## Community Services Planning Department

**RESPONSE TO COMMENTS MAY 26, 2020**

Reference: Aspen Ranch Construction Plans  
Generally located Northeast of the Intersection of Link Road and Kane Road

I have completed the initial review of the Construction Drawings for Aspen Ranch. The following are items that need to be corrected and/or modified. Once all revisions have been addressed please submit 3 full size drawings. If additional agency comments are received, they will be forwarded to you for review and comment.

SILEX STREET PLAN

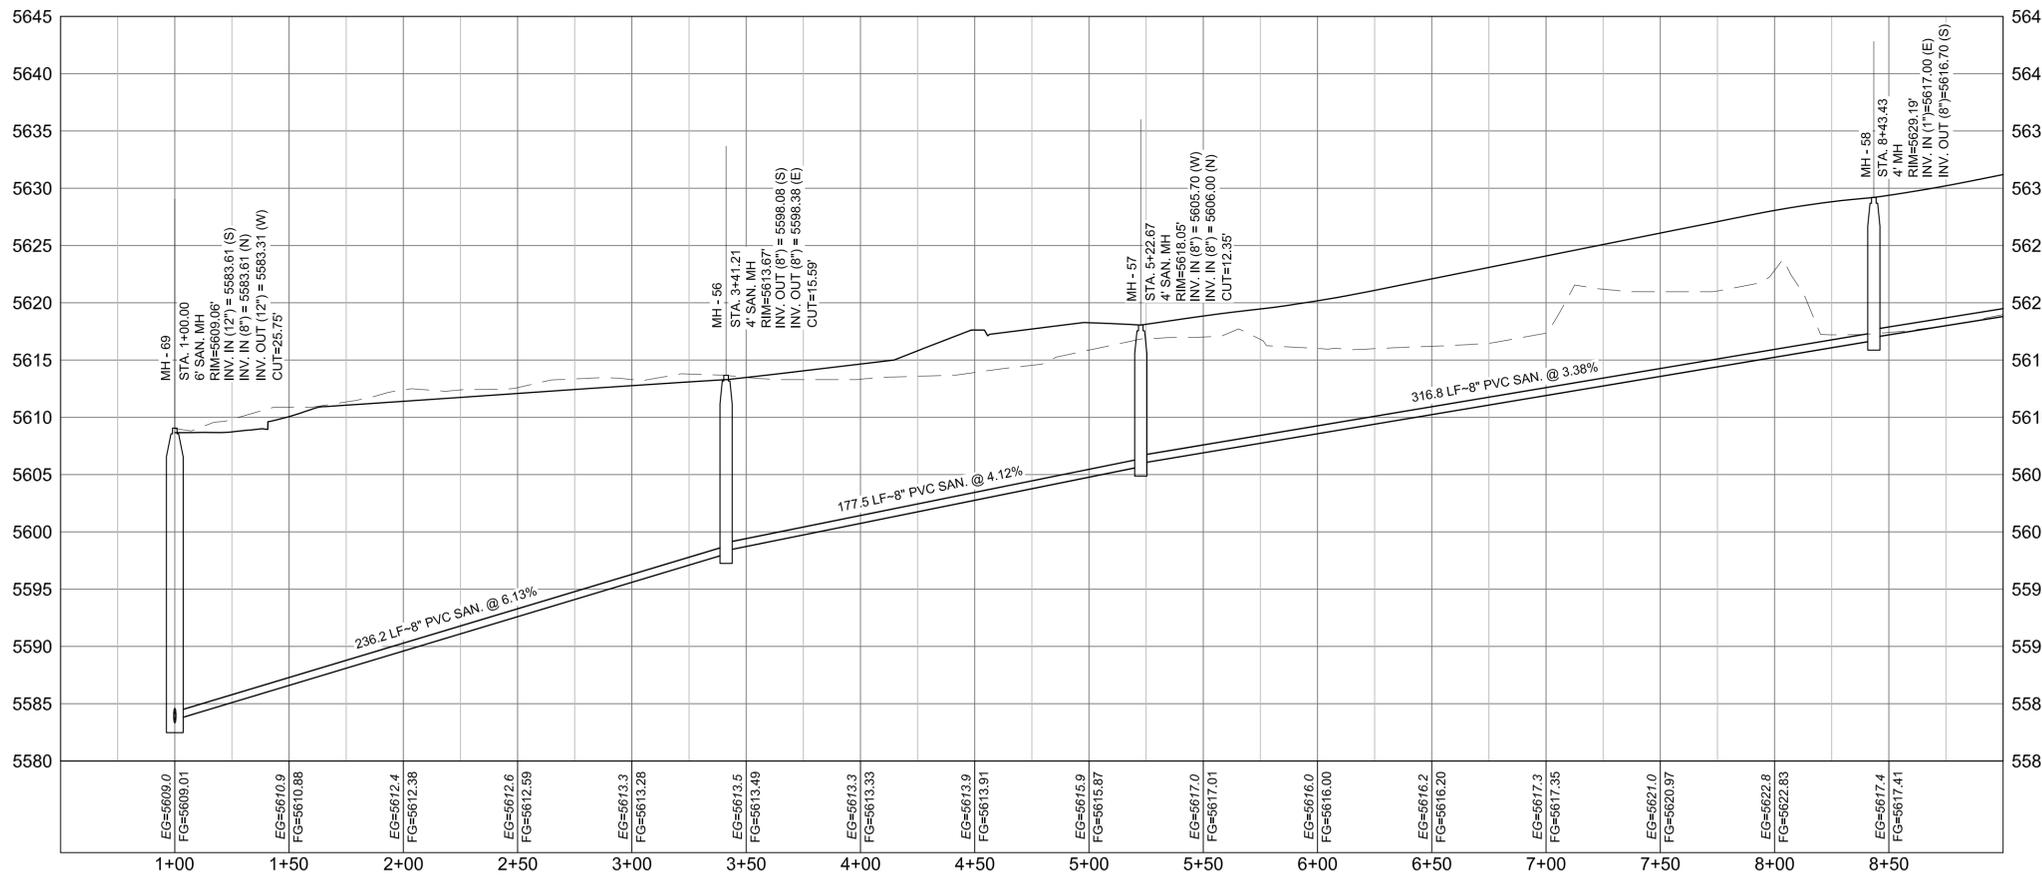
5. The long dead-end Main in Silex Street (Sheet WT07) terminating at a Hydrant will not be permitted; the end of the main must be looped back in at either Link Rd or Watchmen Rd across

Tract F (with an easement) if grade permits.

**ADDRESSED: WATER CONNECTION MADE TO LINK RD. VIA SILEX.**

**EASEMENTS PROVIDED AS REQUIRED.**

CRESCENT MOON ROAD PLAN

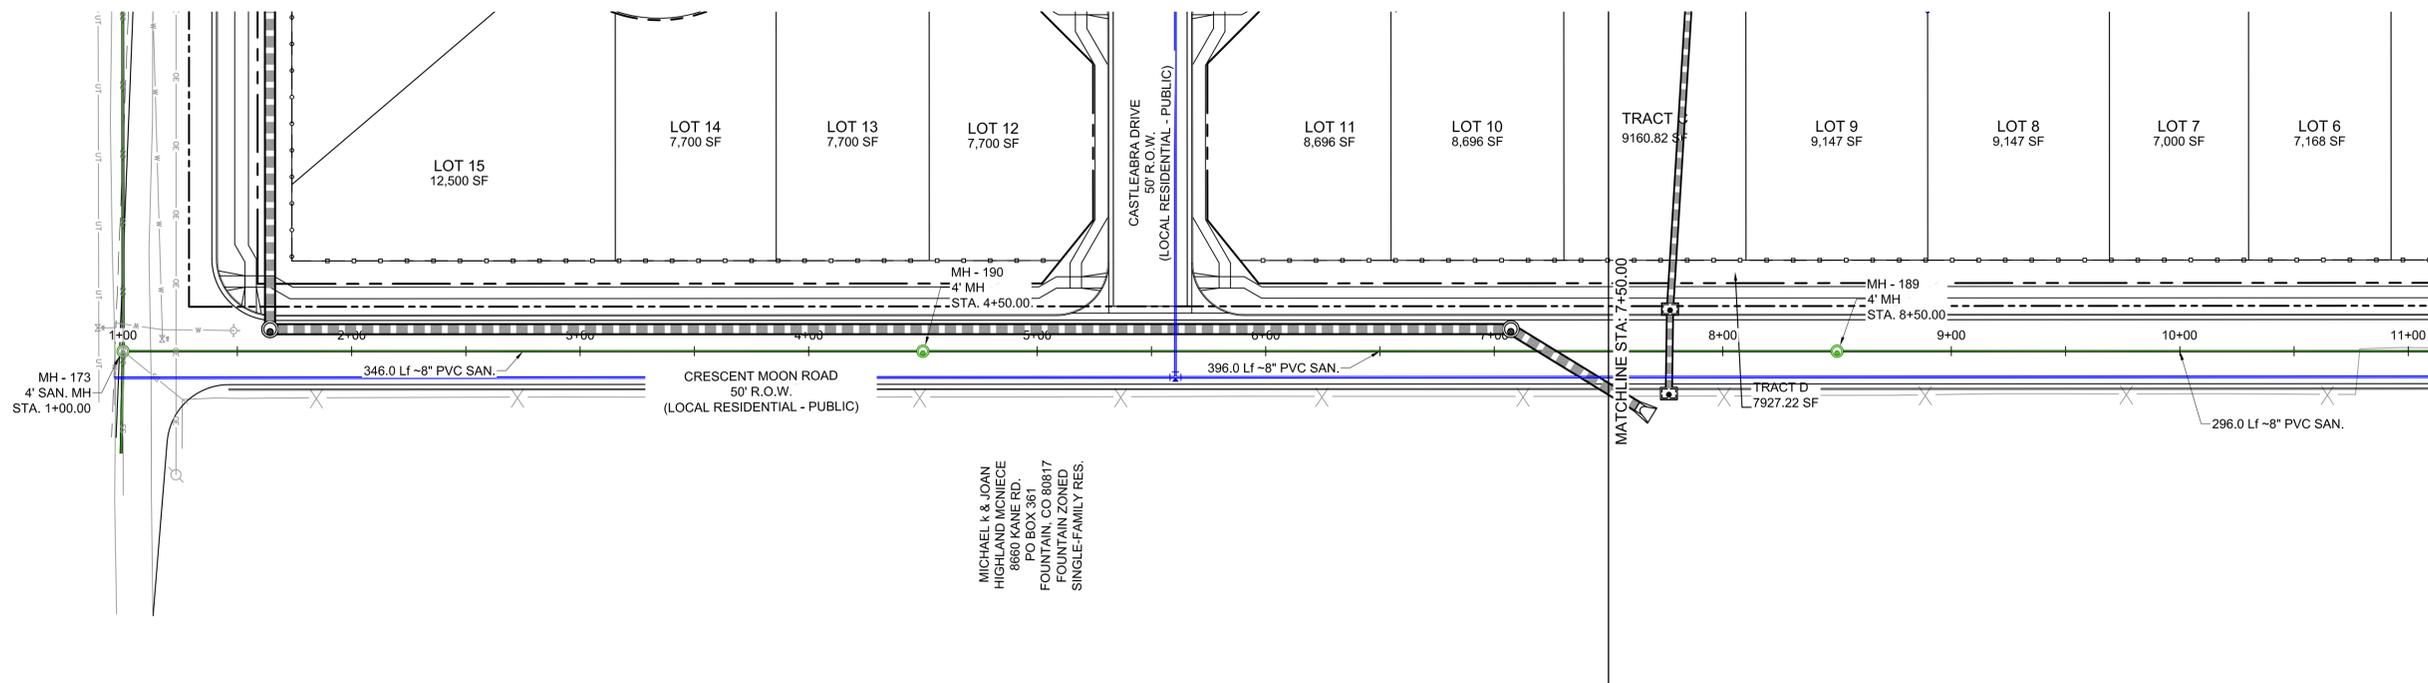
5. Add a sheet index map to each page  
**RESPONSE: ADDED SHEET INDEX MAP AS REQUESTED. NOTED, WILL BE INCLUDED WITH FUTURE CD SUBMITTALS.**
6. Why an 8" dia. pipe in Crescent Moon Street? **RESPONSE: PER DISCUSSION WITH FSD ON 5/12 THE SANITARY PIPE SHALL REMAIN AS SHOWN TO CAPTURE FUTURE FLOWS.**
